Tel: 01903 737756
Email: planning@arun.gov.uk
www.arun.gov.uk/planning
Please ask for: Mrs D Johnson
Email: daun.johnson@arun.gov.uk
Telephone: 01903 737762
Our Ref: R/37/26/PL
Your Ref:
Date: 10th March 2026

Application for Planning Permission

Development: Installation of photo-voltaic panels on the roof on south aisle and adjacent vestries. This application affects the setting of a listed building, affects the character and appearance of the Rustington Conservation Area and is in CIL Zone 4 (Zero Rated) as other development.

Location: Church Of St Peter And St Paul The Street Rustington BN16 3NL

BLOCK PLAN

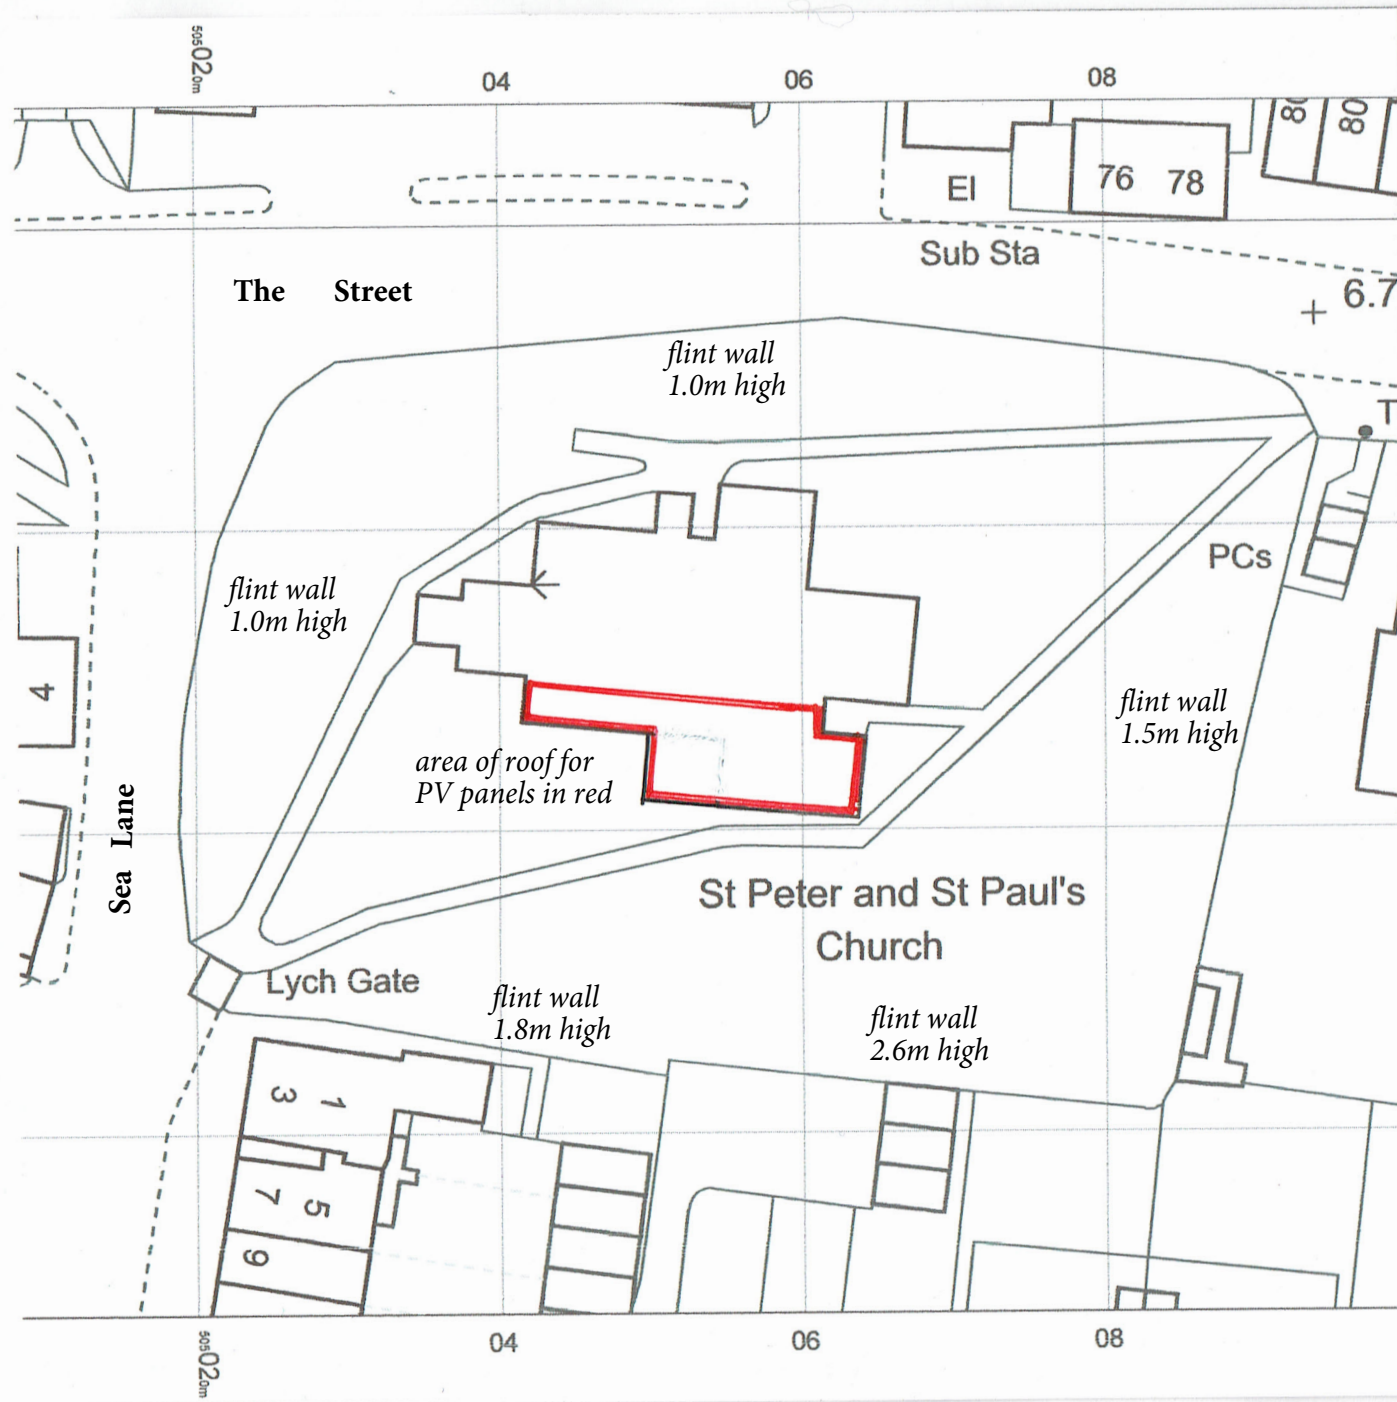
Block Plan

Please highlight the proposed works.
